Application Ref:	2025/0681				Ribble Valley Borough Council www.ribblevalley.gov.uk
Date Inspected:	27/11/2025	Site Notice:	27/11/2025		
Officer:	EP				
DELEGATED ITEM FILE REPORT:					APPROVAL

Development Description:	Proposed demolition of existing dwelling and replacement with detached 3 storey property with integral garage and rear dormer extension.
Site Address/Location:	14 Lancaster Drive Clitheroe BB7 2PD.

Proposed Attic Plan
 1 : 50

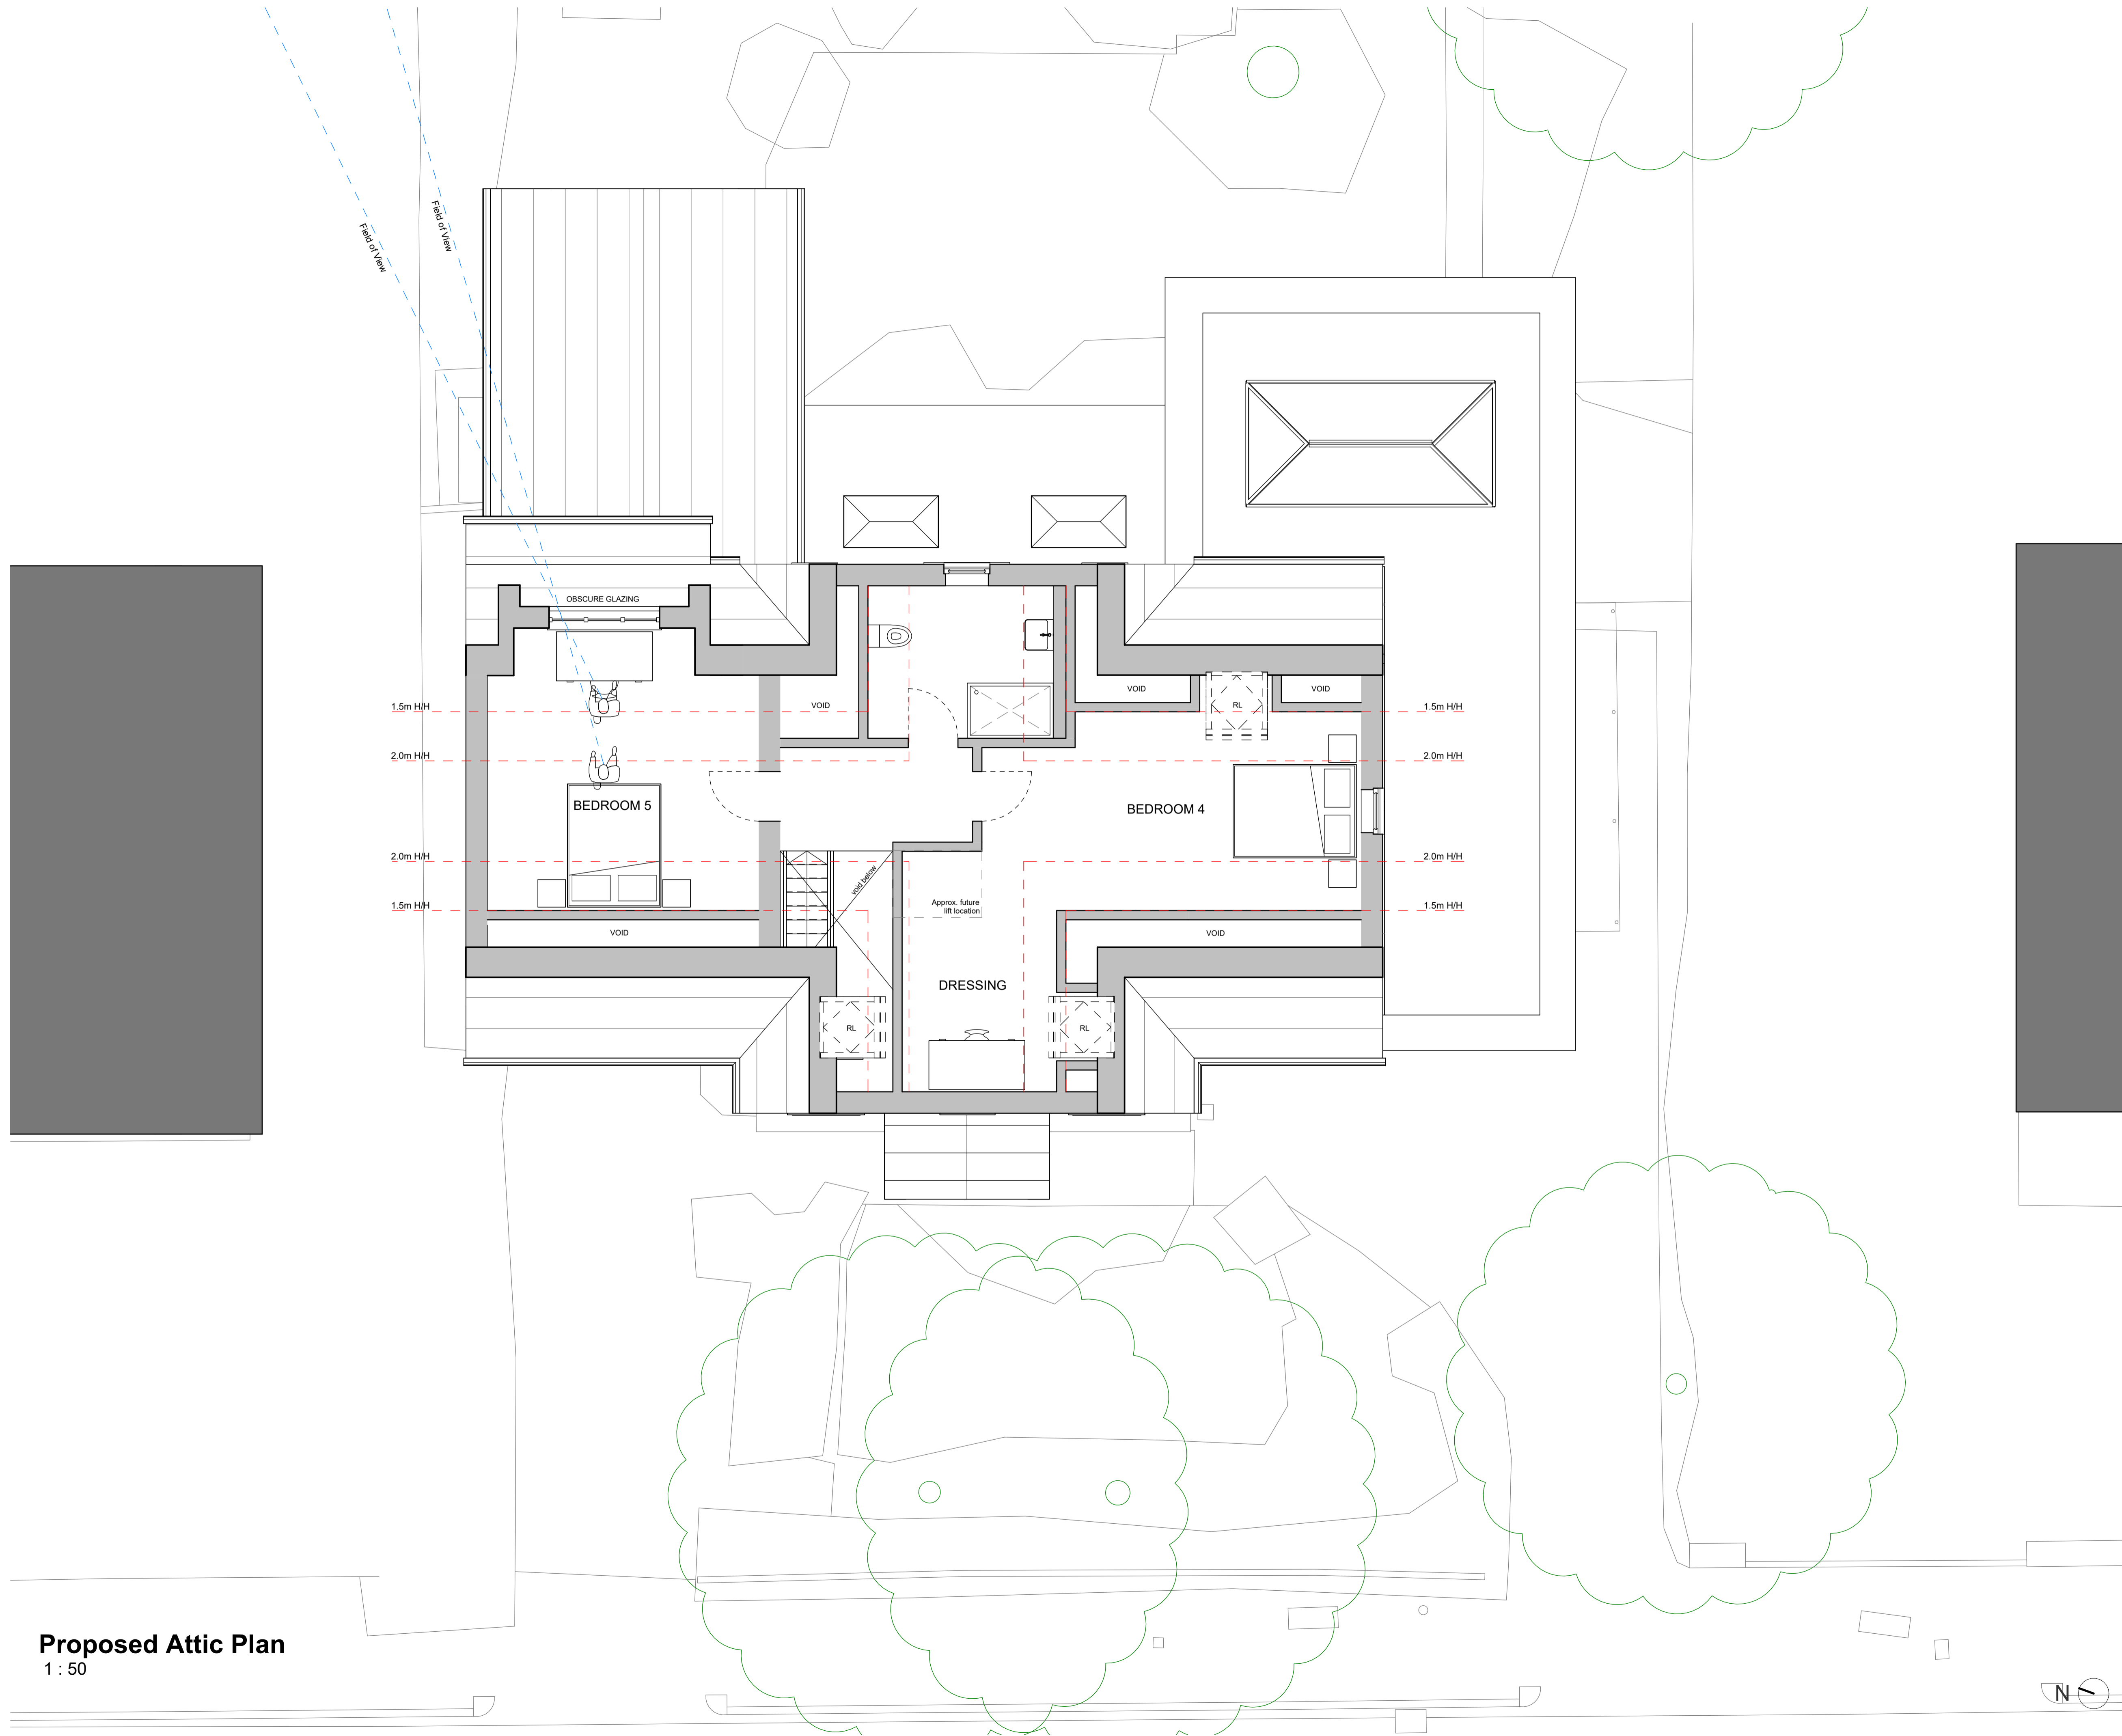
No.16 is located at the northern side of the application site. There is an existing two-storey, flat roof extension at the existing dwelling which comprises a similar footprint and scale to the proposed reverse gable two storey element on the replacement dwelling. Given the comparable nature of the development to this aspect, it is not considered there would be any increased impact in respect of loss of light. There is a proposed single-storey rear projection adjacent of the shared boundary with No.16. There is a sufficient distance between the proposed single storey element and the neighbouring dwelling to mitigate any adverse impact in respect to loss of light to habitable windows. There is a rear dormer extension proposed in the northern side of the roof slope of the replacement dwelling. To mitigate any concerns in respect of increased overlooking, or the perception of such, into neighbouring curtilage, the window proposed in the dormer will be recessed with the dormer cheeks acting as a form of privacy screen. The increased sill height will also reduce any potential for overlooking. Based on these mitigation measures, it is considered that any overlooking into neighbouring curtilage resultant of the proposed dormer would not be sufficient to warrant refusal.

**Proposed First Floor Plan**  
 1 : 50

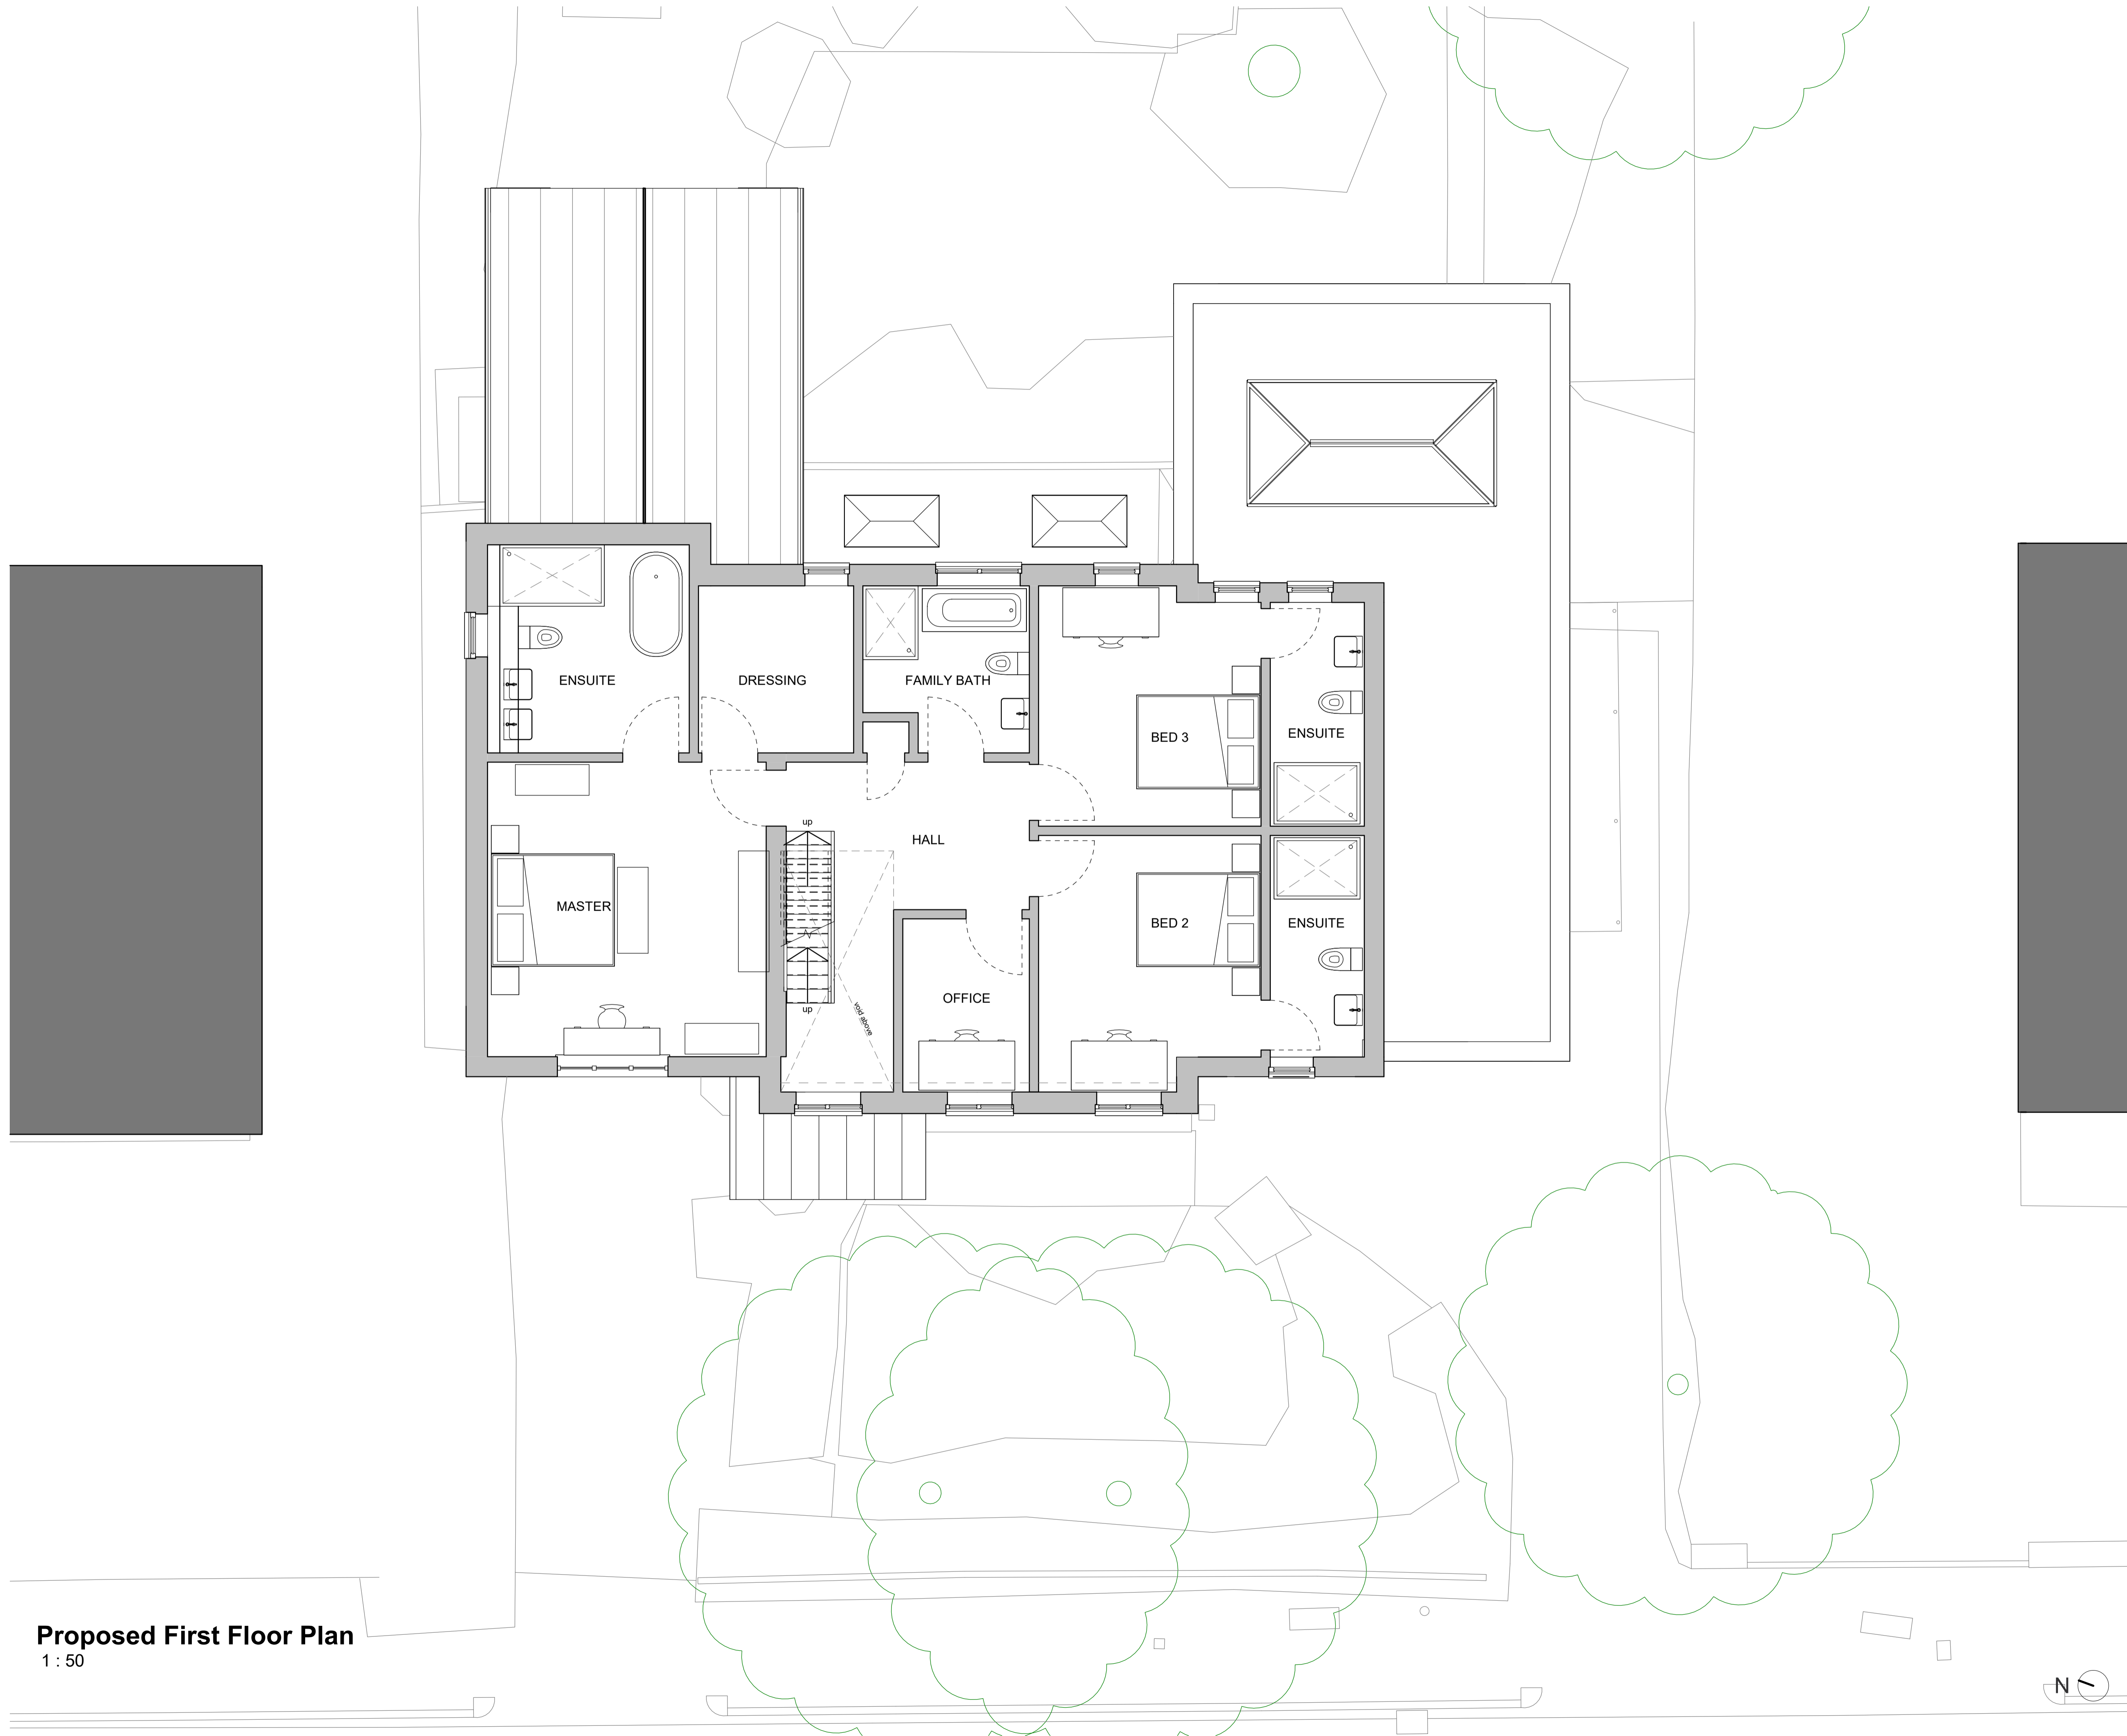
The application dwelling has two immediately adjacent neighbours known as No.16 and No.12 Lancaster Drive. No.12 is located to the south of the application site, where the development will involve a new two storey element, along with single storey side and single storey rear elements. The proposed two storey element will not project beyond the existing principal or rear building lines of the existing dwelling and therefore there will be no adverse impact in respect to loss of light or overbearing impact in this respect. The single storey side and rear part of the proposal along this southern boundary is modest in respect of scale. No.12 benefits from its own extensions and outriggers and therefore the proposed single-storey element will not project beyond the rear building line of No.12. Again, therefore no loss of light is anticipated. There is one new window opening proposed in the south eastern side elevation at second floor level. To mitigate any potential overlooking into neighbouring curtilage, this window should be obscurely glazed. This can be secured via planning condition.

Proposed South West Elevation
 1 : 100

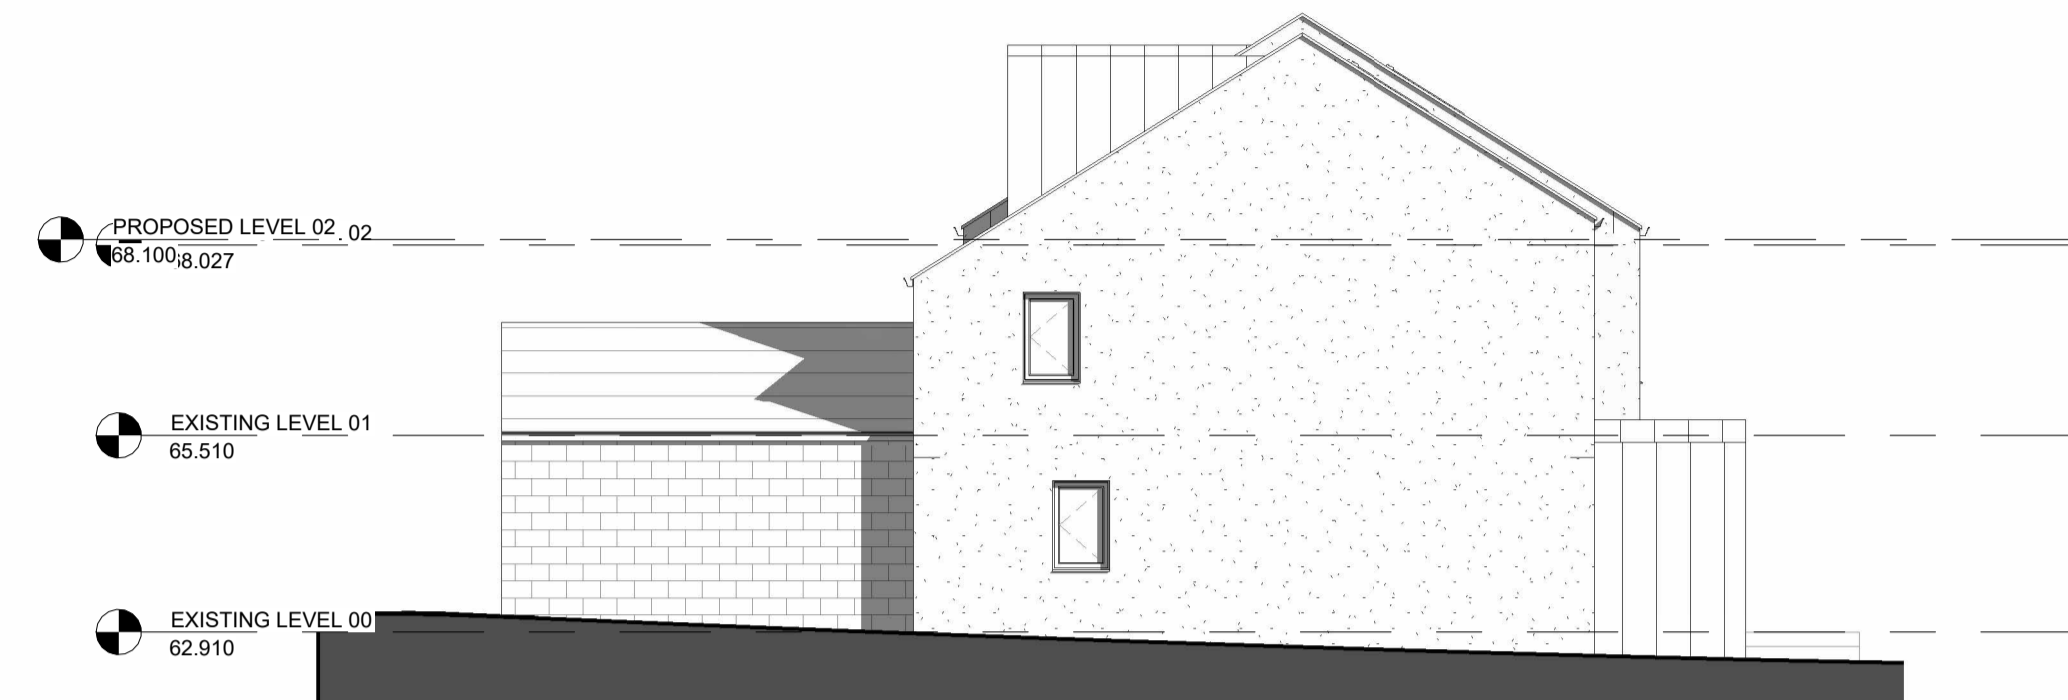
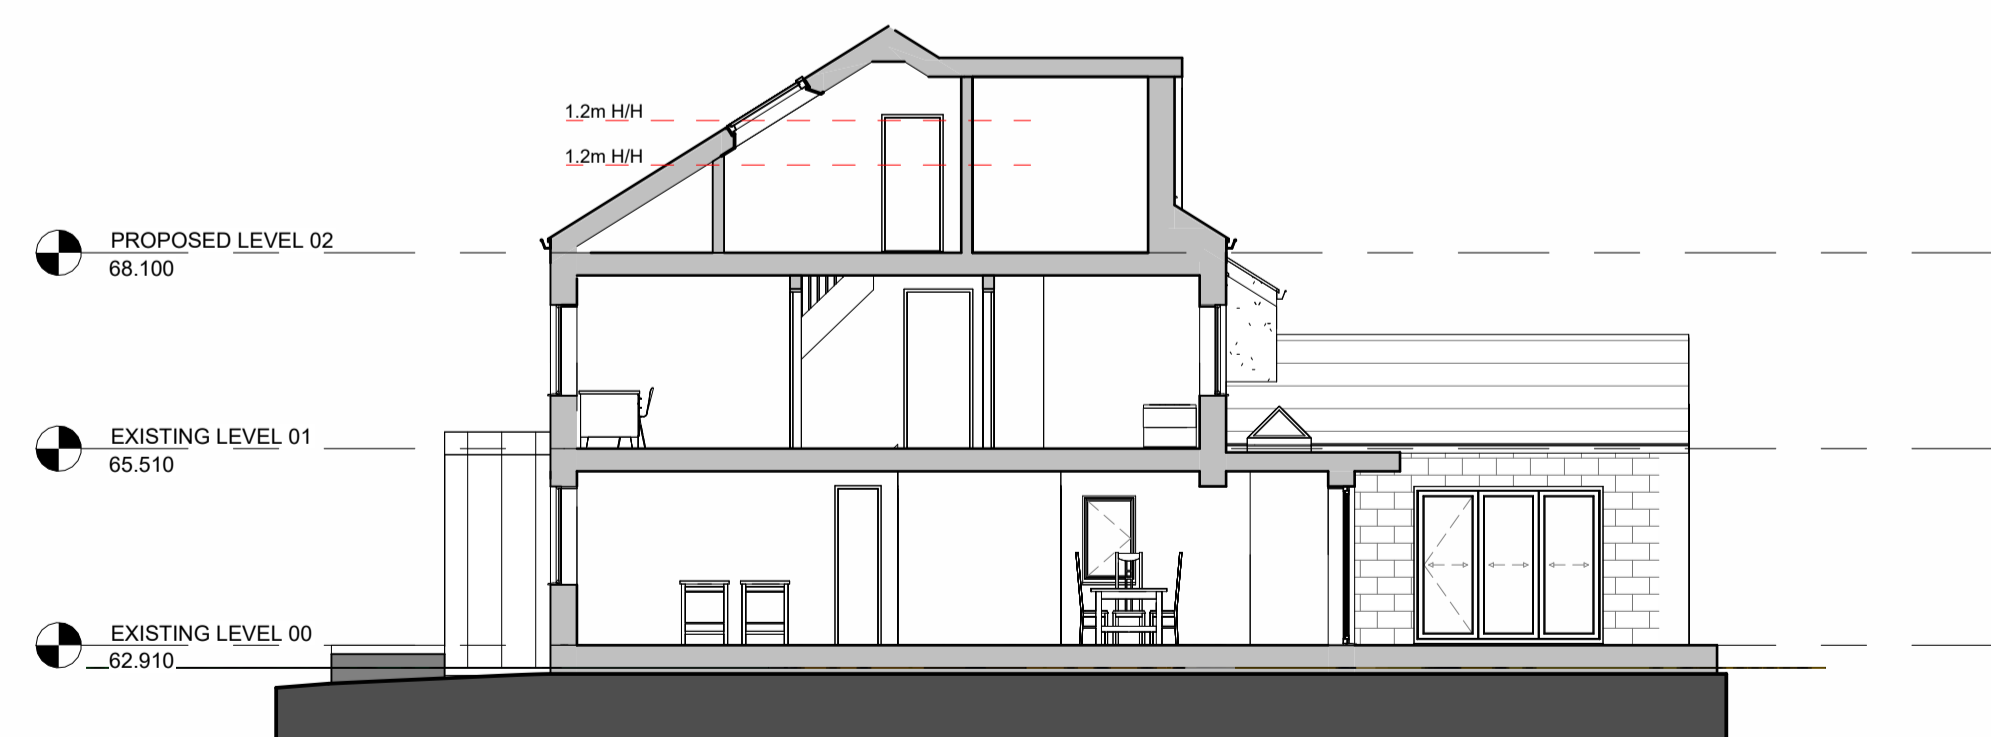
In respect of footprint, the overall increase in scale when compared to the existing dwelling is fairly substantial, primarily by virtue of the additional storey and increase in width. Whilst the proposed dwelling is greater in regard to overall bulk and massing, given the varying styles of dwelling in the vicinity, it is not considered it would read as out of character. Despite the additional storey, given the nature of the roof form proposed, the dwelling will not notably exceed the height of its immediate neighbours. The application site also benefits from a large curtilage, greater than that of its immediate neighbours, the dwelling will therefore not appear overdeveloped within its plot. As such, the proposed replacement dwelling will integrate sufficiently into the street scene and will not read as out of character.

In respect to materials there are a variety found in the vicinity and as such there is scope for a mix of materials to be utilised. Natural stone, render, small elements of timber cladding and the aluminium windows as proposed would be an acceptable arrangement.
